**Re: CALLE TRANQUILLO SUBDIVISION (G-12/D27)**  
**Engineers Certification for Release of Financial Guaranty**  
**Engineers Stamp dated 2/6/2002**  
**Engineers Certification dated 6/20/2003**

**RE: Grading and Drainage Plan For Calle Tranquilo (G12-D27) Dated  
February 6, 2002**

**RE: Grading and Drainage Plan For Calle Tranquilo (G12-D27) Dated  
January 24, 2002**

**Re: Calle Tranquilo Subdivision Grading and Drainage Plan (G12-D27) with Engineer's Stamp dated February 6, 2002**

TITLE: CALLE TRANQUILO SUBDIVISION GRADING & DRAINAGE PLAN

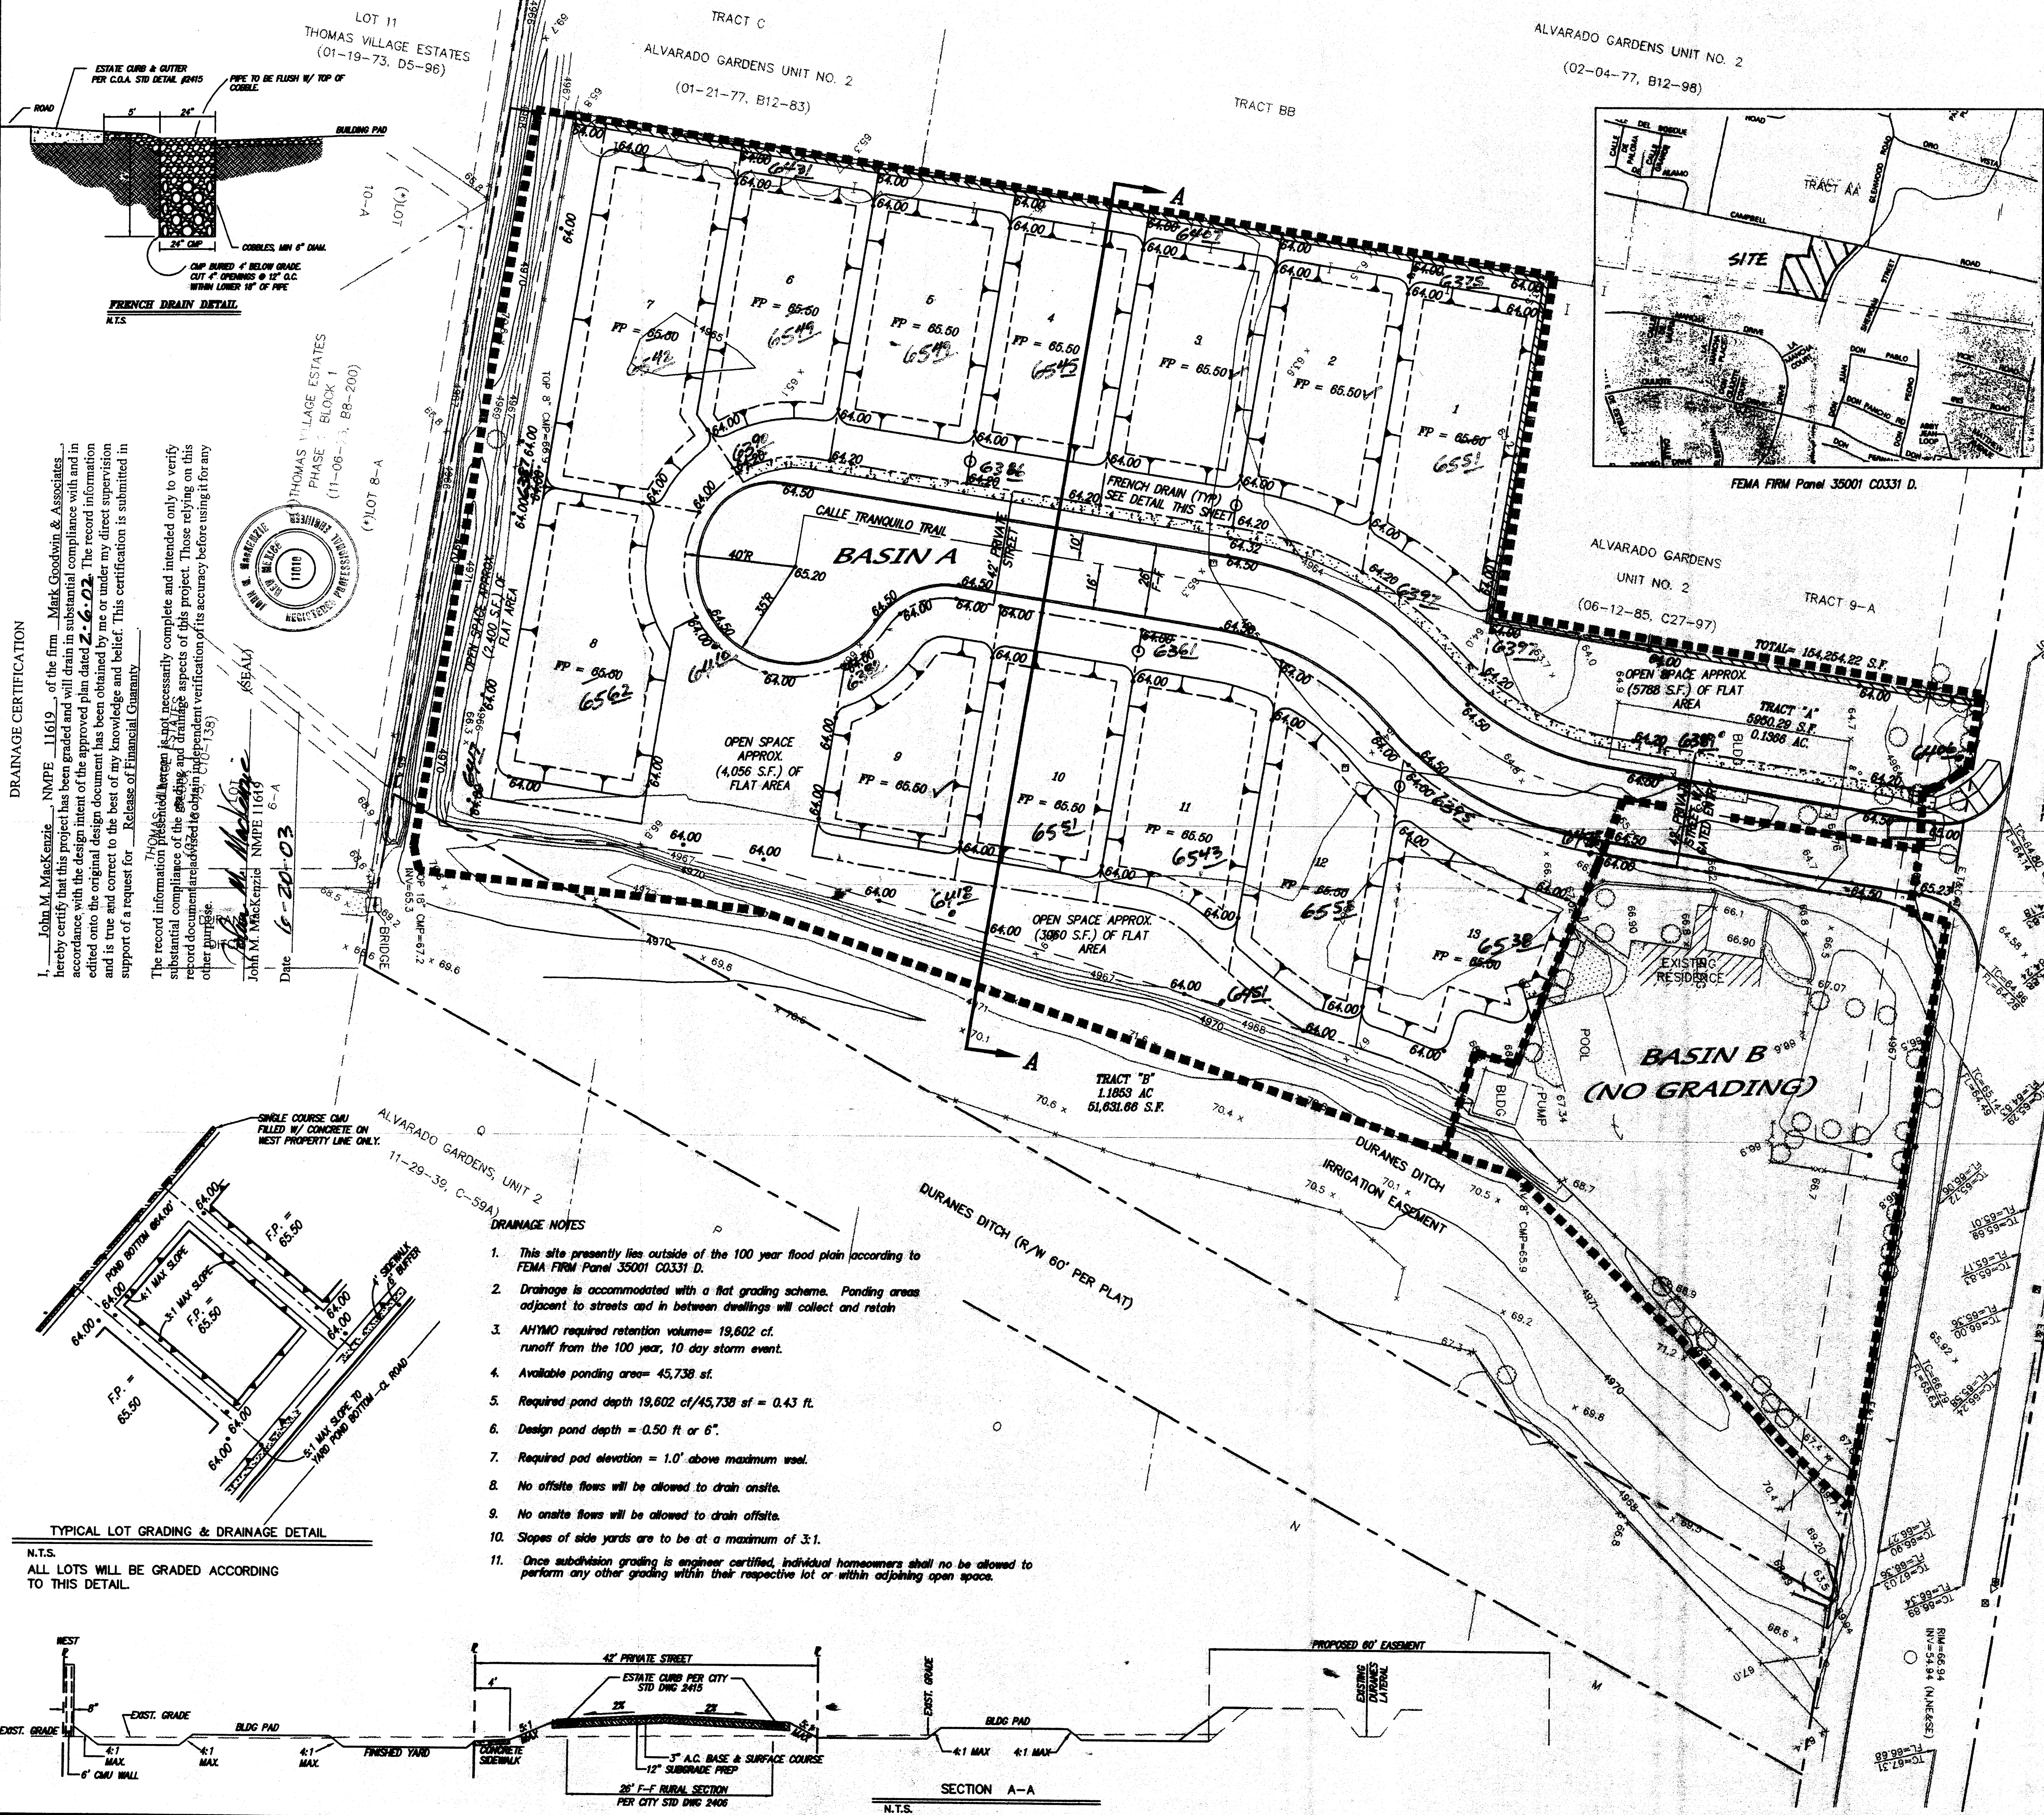
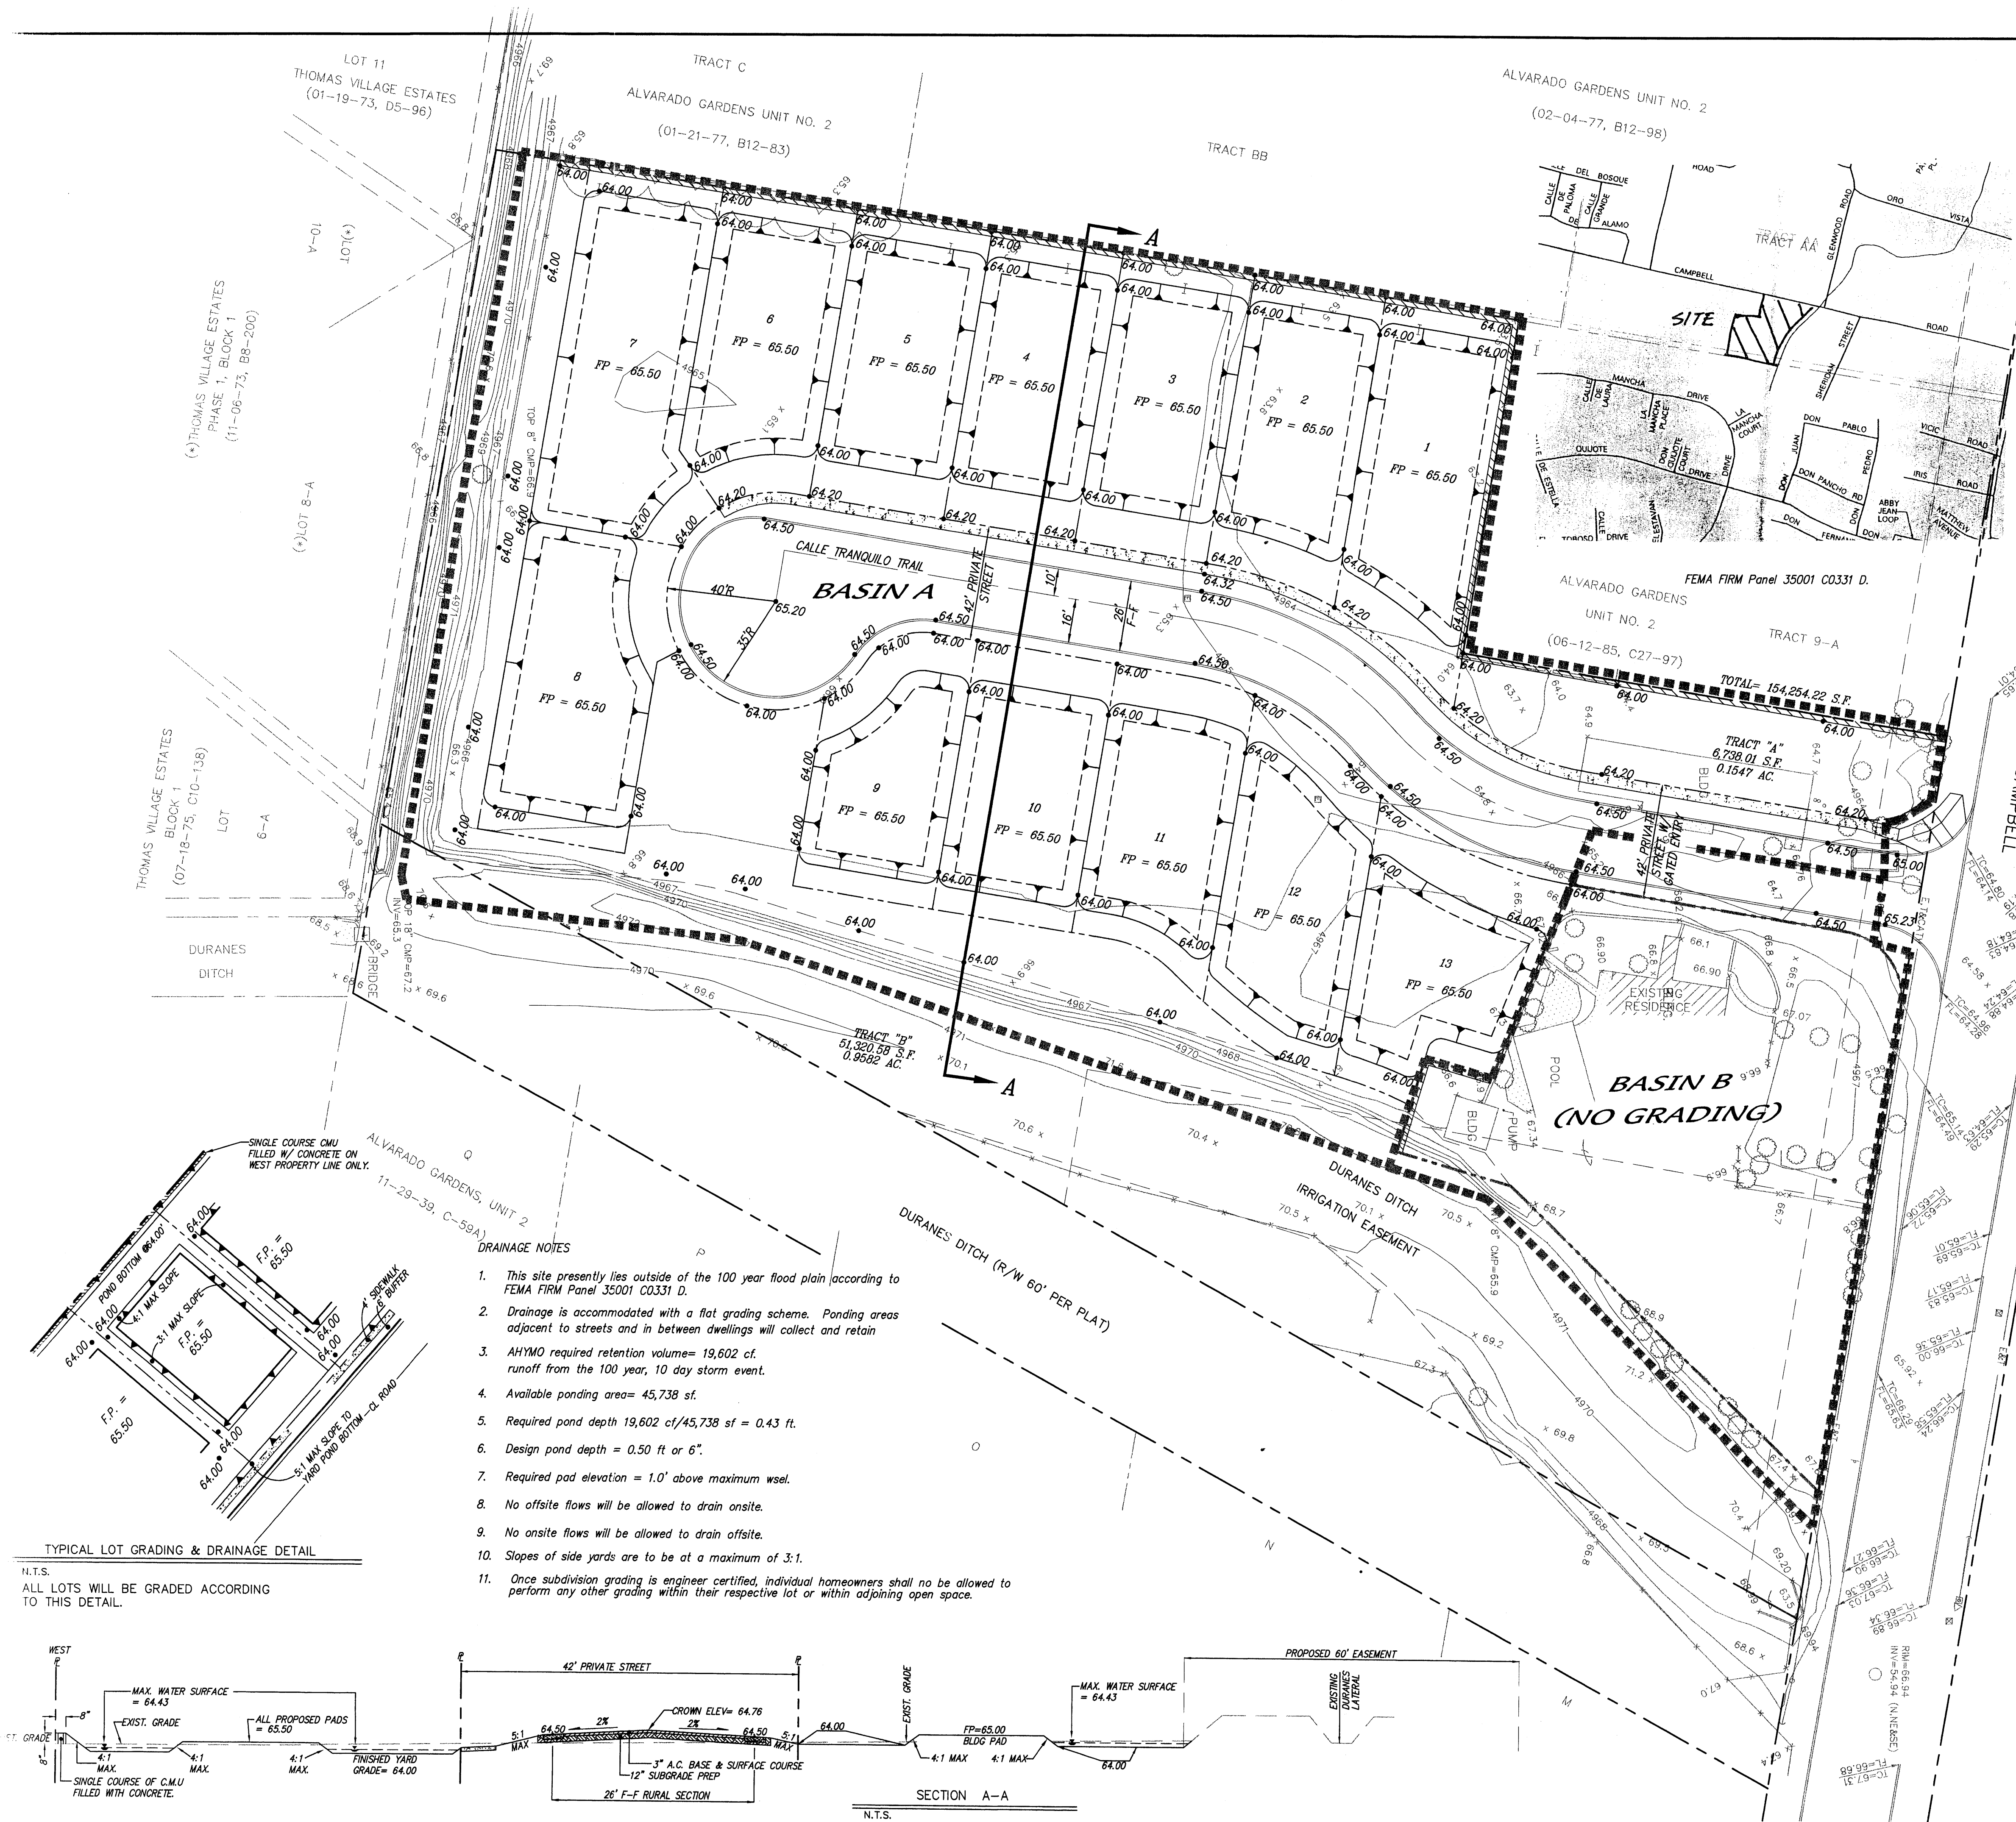
I have reviewed the referenced drainage plan received January 24, 2002 and forward the following comments. The DPM criteria indicates that the sum of all the impervious area contributing to the lot should not be greater than 45% including the street and the sidewalk. I checked this criteria and it did not work for two of the lots. As per our conversation I believe that you could include a cluster of lots that are close together to determine the 45% criteria. These lots should be close together and can drain to each other. Please submit your proposal for our review and approval.

As suggested by you and other members of the Hydrology Division staff, I have investigated another relatively high-density development similar in nature to the flat-grading scheme we have employed on the referenced subdivision in response to your hesitation in approving our grading and drainage plan. The question was to investigate the Meadows on the Rio Grande Subdivision ("Meadows") in an effort to determine if problems and/or complaints had been received from residents relating to the runoff that would be documented in the Meadows drainage file (G12-D19).

The Meadows was split into Unit 1 and Unit 2 with the dividing line being by Don Fernandez Road. The grading and drainage plan was designed by Isaacson and Arfman and approved in 1993. Nowhere in the file did I find an indication of complaints being lodged by residents, except one related to the escape of irrigation water from the Duranes Ditch in connection with the subdivision's original zone change, which would have been before platting. There was nothing in the file post-construction of the subdivision improvements. Fred Aguirre did, however, mention that the typical flat-grading schemes often create problems for corner lots where two streets come together. For the subject subdivision this shouldn't be anticipated because there are no intersecting streets, only one cul-de-sac. Furthermore, there is flat open space area directly adjacent to this cul-de-sac and also within other areas around the subdivision which the Meadows does not have. Unfortunately, there is nothing in the DPM under "flat-grading" that gives credit for a subdivision's open space. With 15,343 square feet of additional flat open space provided adjacent to the homes within this subdivision, there is a ponding area equivalent to an additional three lots. I had estimated and labeled these areas on the plan.

Also, in an effort to reduce the chances for ponding to occur in front of the future residences, I have designed a french drain at four locations. This simple design will help runoff percolate into the site subgrade more effectively than waiting for it to evaporate or otherwise percolate naturally.
